KITTITAS COUNTY
DEPARTMENT OF PUBLIC WORKS

MEMORANDUM

TO: All Staff
FROM: Public Works Plan Review Team
DATE: October 7, 2022
SUBJECT: LP-22-00004 Suncadia Ph 1 Div 14

SUNCADIA PHASE 1 DIVISION 14
PRELIMINARY PLAT

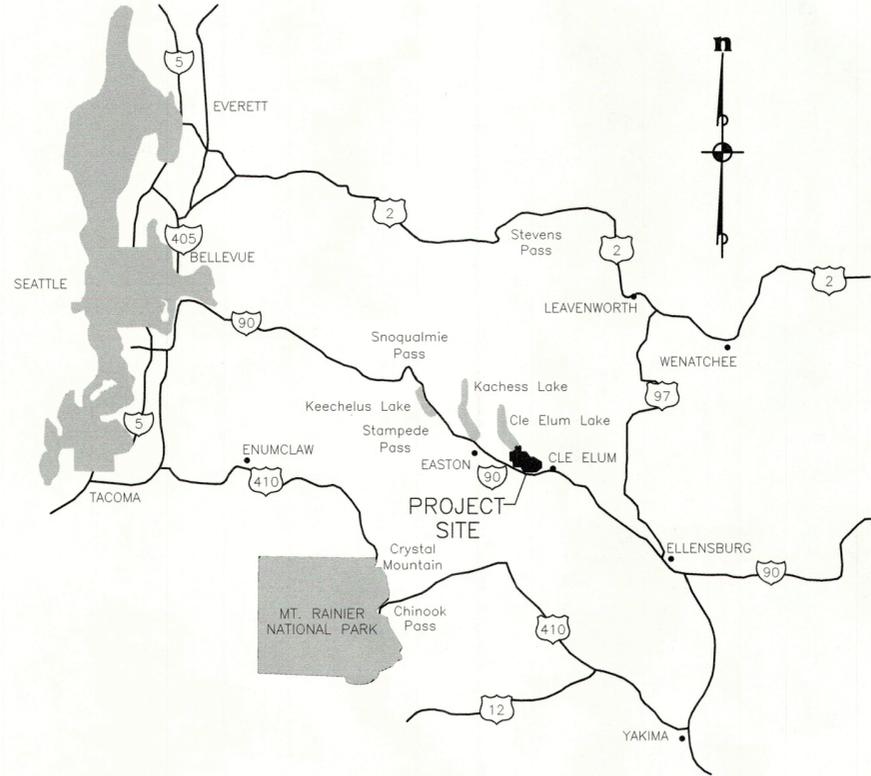
<p>A portion of parcel 20-15-19054-0003 is located in the FEMA identified special flood hazard area (100-year floodplain). Per KCC 14.08.220, all subdivisions shall show on the face of both the preliminary and final plat, for either short or long plats, the boundary of the 100-year floodplain and floodway.</p> <p>Prior to plat approval the 100-year floodplain boundary must be included on the face of the plat.</p>
<p>WATER MITIGATION/ METERING</p>	<p>No comments</p>

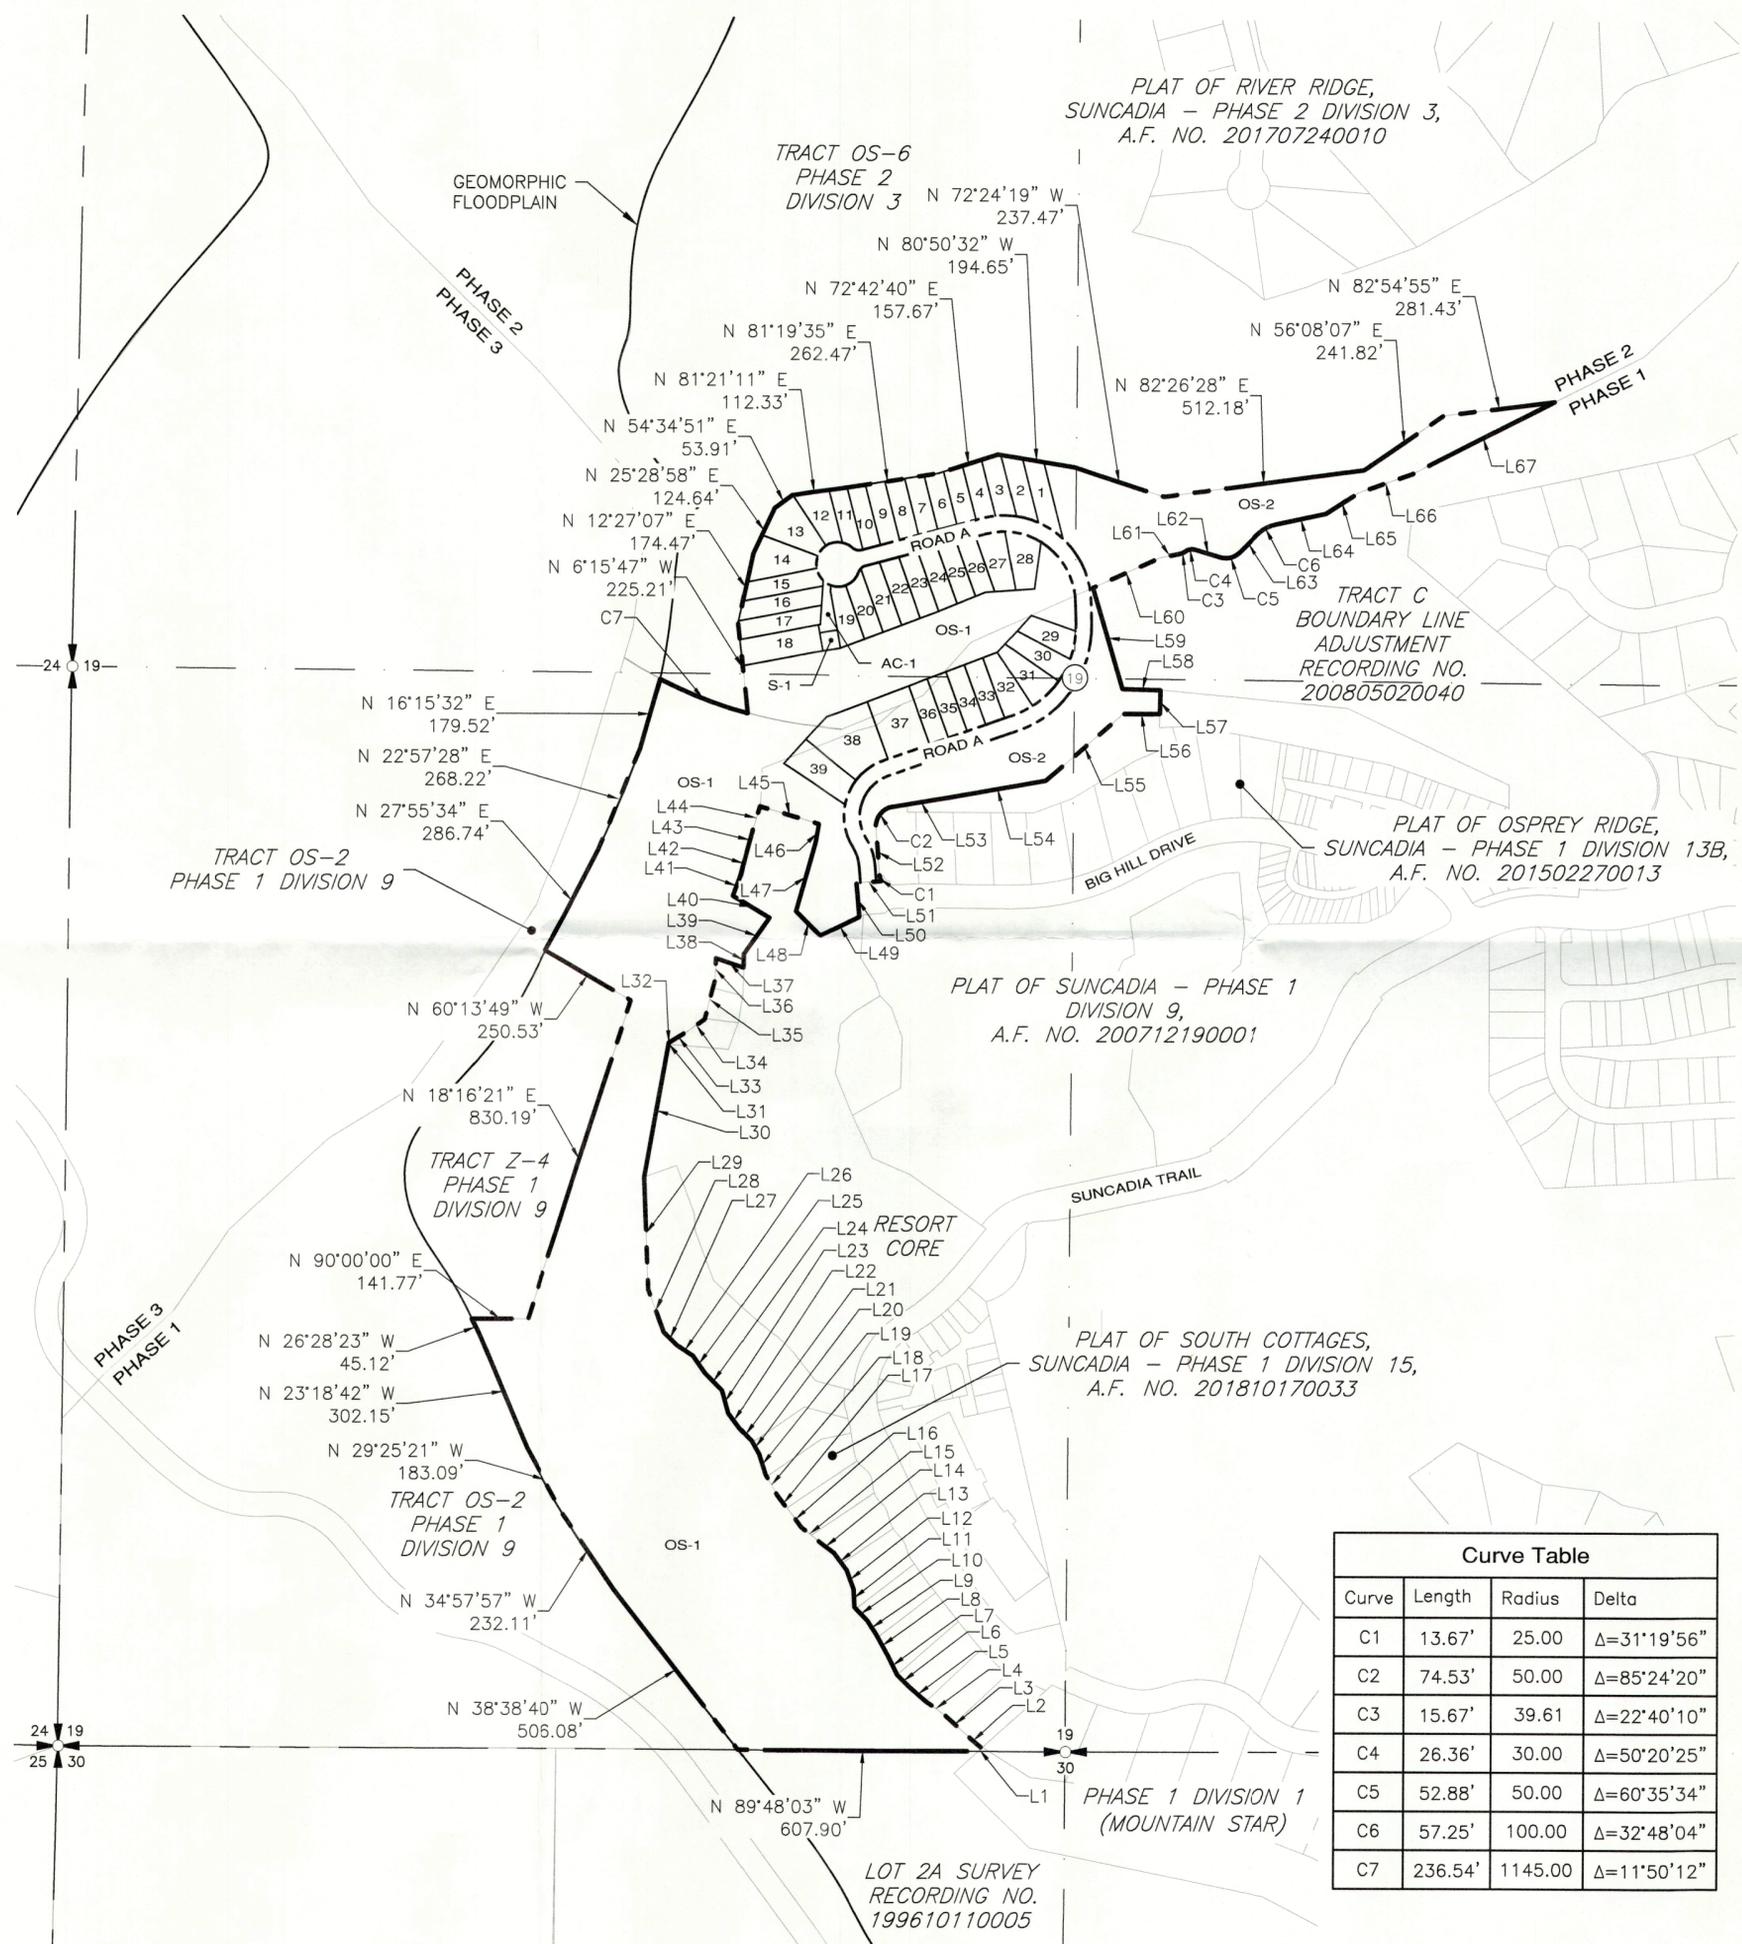
<p style="text-align: center;">EXAMINED AND APPROVED This ____ day of ____, A.D., 20____.</p> <p style="text-align: center;">_____ Kittitas County Engineer</p> <ol style="list-style-type: none"> 4. Please submit engineered plans to Public Works for a Civil Review. This should be completed prior to Final Plat. 5. While Suncadia is in the process of completing the Traffic Monitoring Plan, please submit an update report detailing what monitoring has been completed. This update report will be required for Final Plat. 6. Please provide an inventory of equivalent residential units, or the accounting method utilized in the water system plan, affirming sufficient capacity serving the plat. 7. Please provide an inventory of equivalent residential units, or the accounting method utilized in the general sewer plan, affirming sufficient capacity serving the plat.
<p>SURVEY</p>	<p><u>All pages:</u></p> <ol style="list-style-type: none"> 1. The heading at the top of the pages shall include Name of Subdivision, Section, Township, Range, County and State. <p><u>Sheet 1</u></p> <ol style="list-style-type: none"> 2. Include the additional owner of OS-3, Plat:11-78 in the owner block. Per county GIS this does not match the owner of record shown. 3. Include the Engineer of Record 4. Sewer, stormwater, and road cut/fill slope easements should be contemplated. All easements shown upon referenced conceptual and preliminary documents shall be included on the face of the Plat. 5. Paragraph one of the Legal Description should be revised to read Book 11 of Plats, Page <u>78</u> through 82. <p><u>Sheets 2 and 3</u></p> <ol style="list-style-type: none"> 6. Include ownership, width and surfacing for Big Hill Drive (EX: 60' wide Private R/W - Paved) 7. Please show Road A as a 40' Private ROW 8. Lots OS-1, 37, 38 and 39 all have portions of a prior Open Space parcel (OS-3, Plat 11-78). Development of open Space should be resolved with CDS. <p><u>Sheet 4</u></p> <ol style="list-style-type: none"> 9. Show Cle Elum River.
